**Planning Department  
Transportation Development Services**

October 28, 2014

**Re: Office Warehouse, 3440 2<sup>nd</sup> Street NW**  
**Traffic Circulation Layout**  
Engineer's/Architect's Stamp dated 10-20-14 (G14-D087)

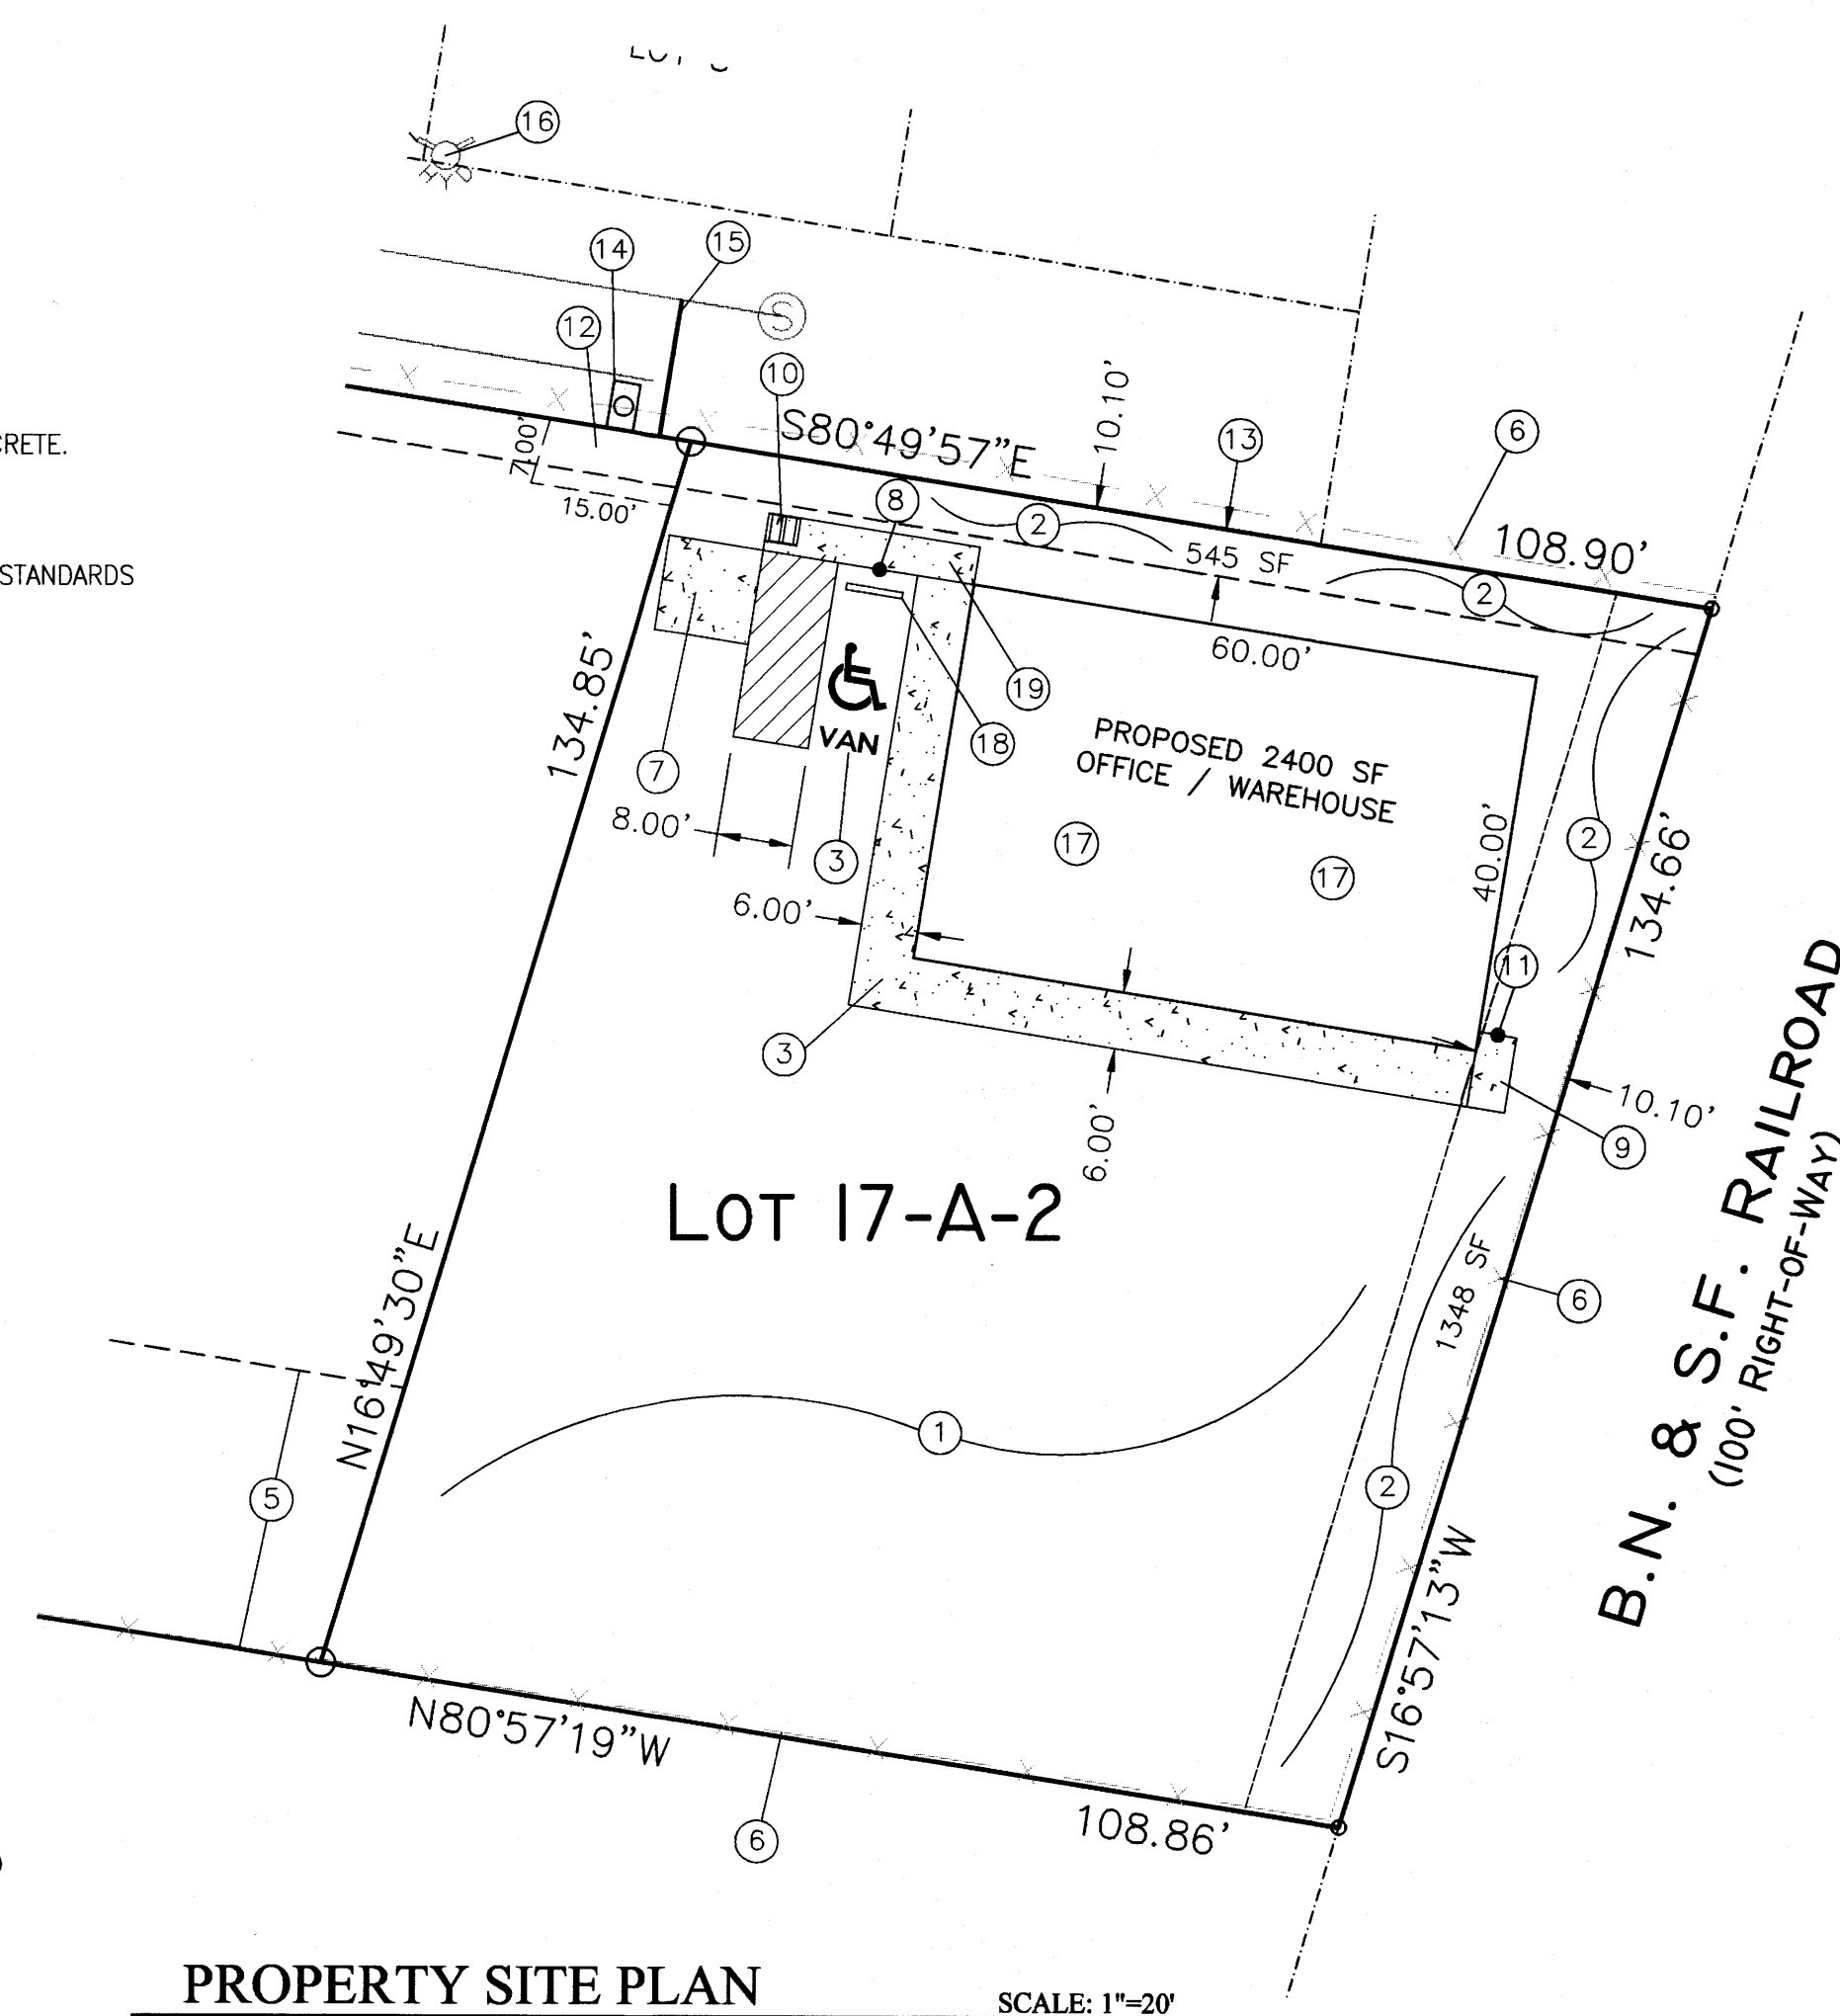
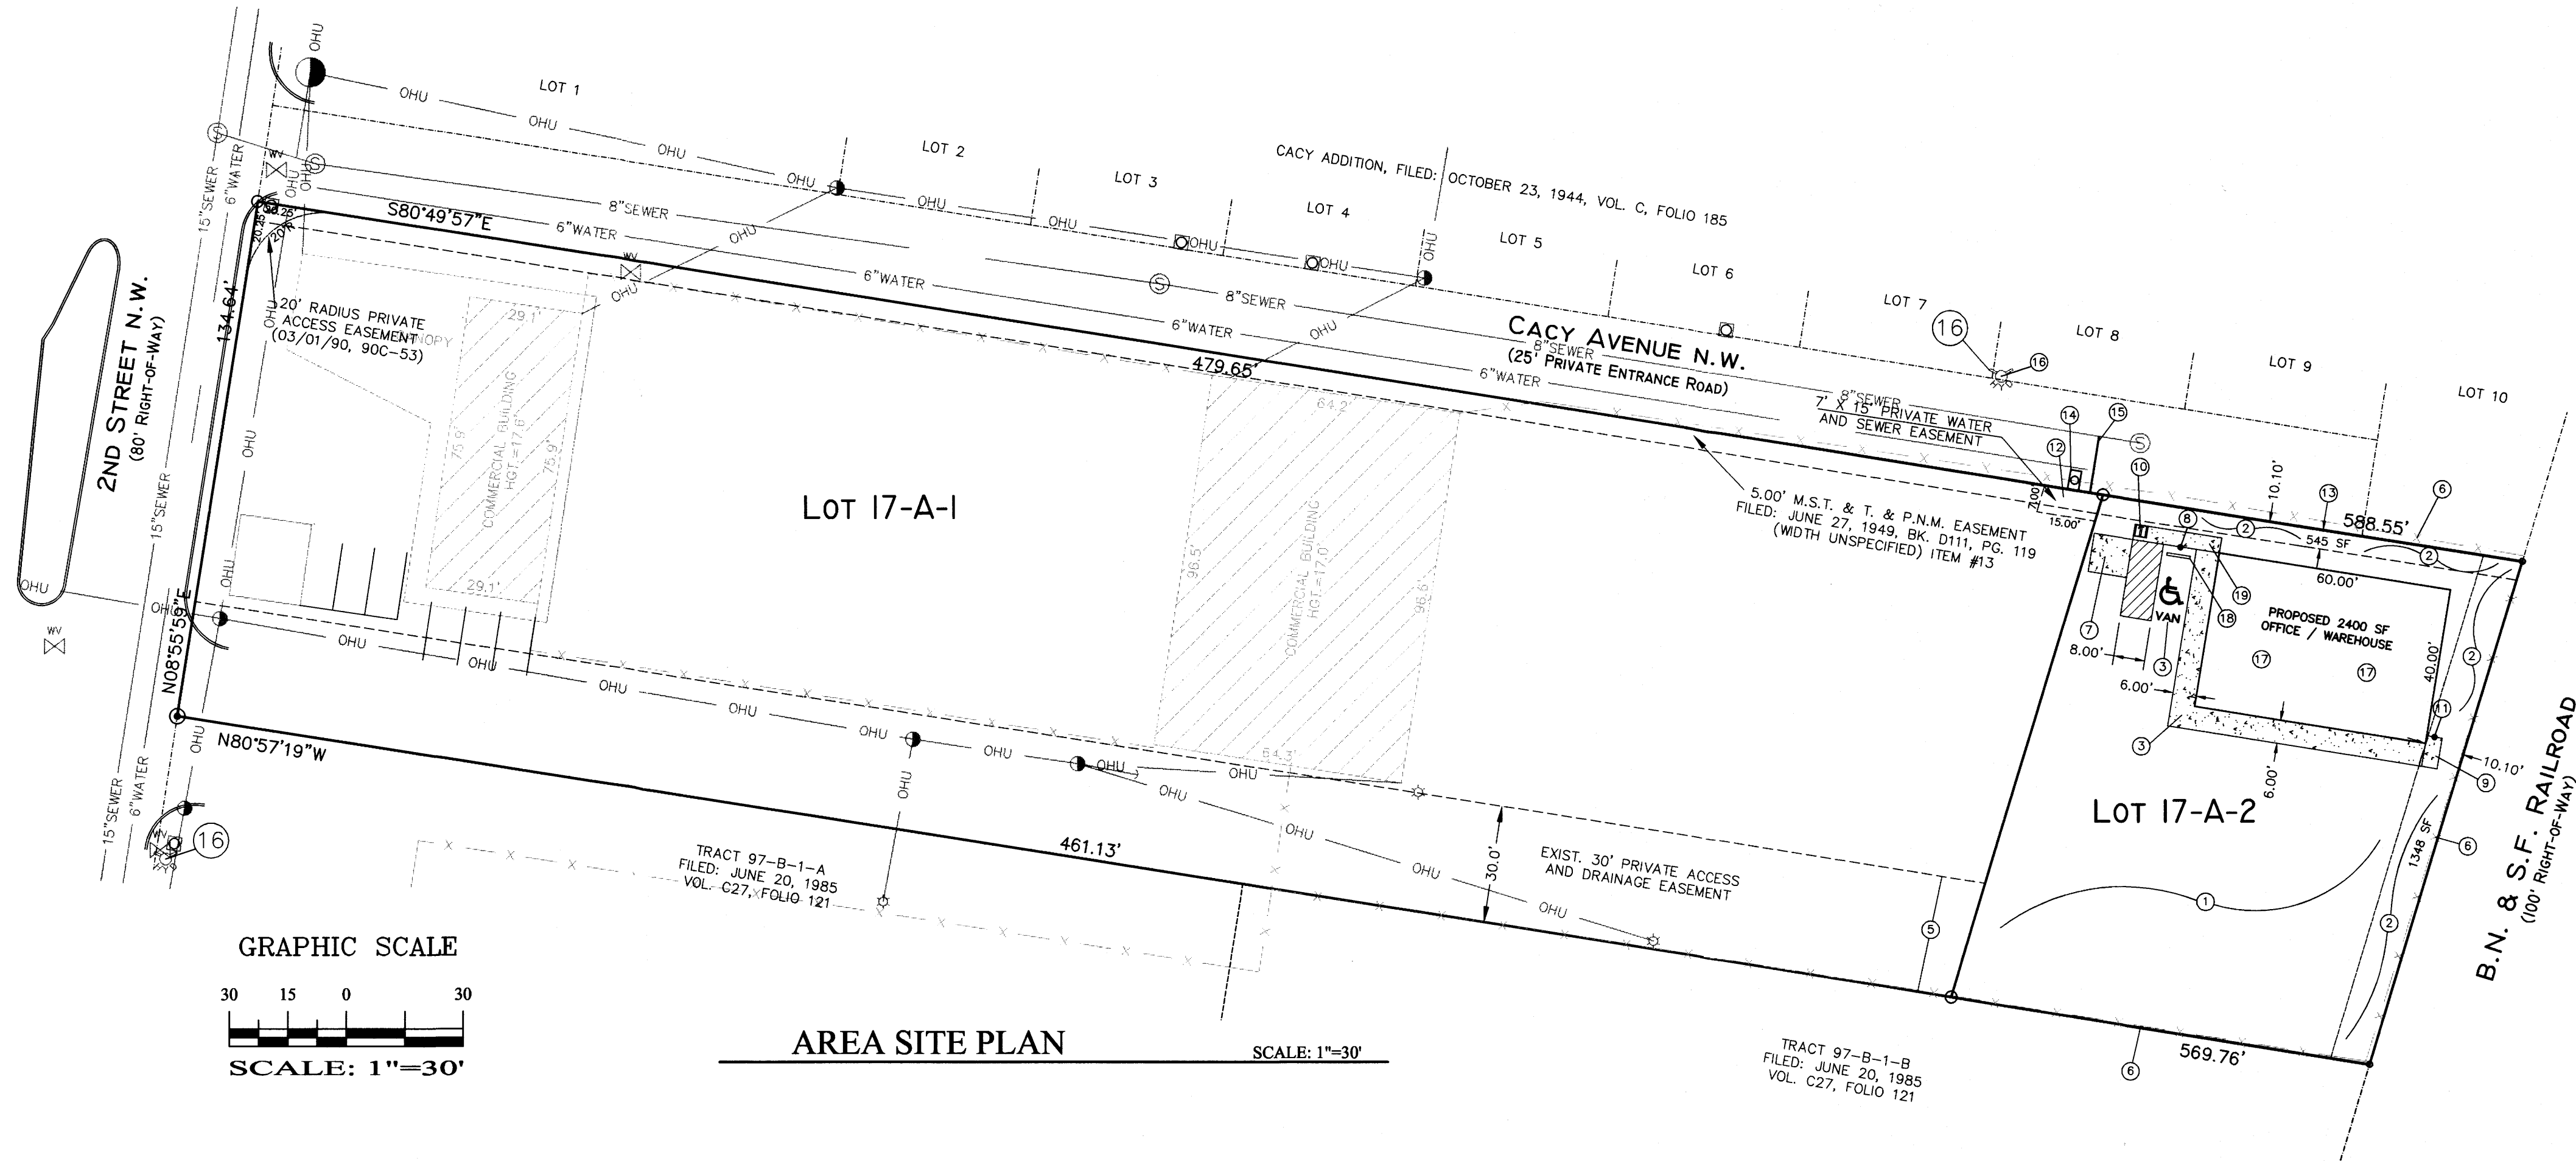
1. Label each existing building on Lot 17-A-1 as "Existing Building to Remain", and label the existing pavement width and/or gravel roadway width on adjacent roadways. Show existing access to Lot 17-A-1.

2. Label the DRB case number for the Existing 30-foot Private Access and Drainage Easement.
3. Please identify all the proposed doors for the proposed office and warehouse including handicapped access and the proposed garage doors for the proposed parking inside the warehouse. Show all door widths.

4. Please list the width and length for all parking spaces. The handicap accessible spaces must be a minimum of 8.5 feet in width and 18 feet long.
5. The ADA van accessible sign must have the required language per 66-7-352.4C NMSA 1978 **"Violators Are Subject to a Fine and/or Towing."**

6. The ADA access aisle shall have the words **"NO PARKING"** in capital letters, each of which shall be at least one foot high and at least two inches wide, placed at the rear of the parking space so as to be close to where an adjacent vehicle's rear tire would be placed. (66-1-4.1.B NMSA 1978)

7. For Lot 17-A-2, extend the proposed 6-foot sidewalk all of the way to the property line along the south side of Casey Avenue.
8. Handicapped access is required to be paved. Both the handicapped parking space and the van accessible space must be paved. The remaining driving area may be recycled asphalt or gravel as called out by Keyed Note 1 on the site plan. Maintain the new 6-foot sidewalk as concrete or asphalt as called out

- on the site plan as per Keyed Note 3 as long as a different surface is provided for the pedestrian walkway than the driving area. For the asphalt surface, show the thickness of asphalt proposed.
9. The bike rack called out by Keyed Note 10 on the site plan is in the way of the handicapped access from the van accessible aisle and needs to be moved to a location where it does not interfere with wheelchair access.
  10. "Chain link fence" is misspelled on Keyed Note 6.
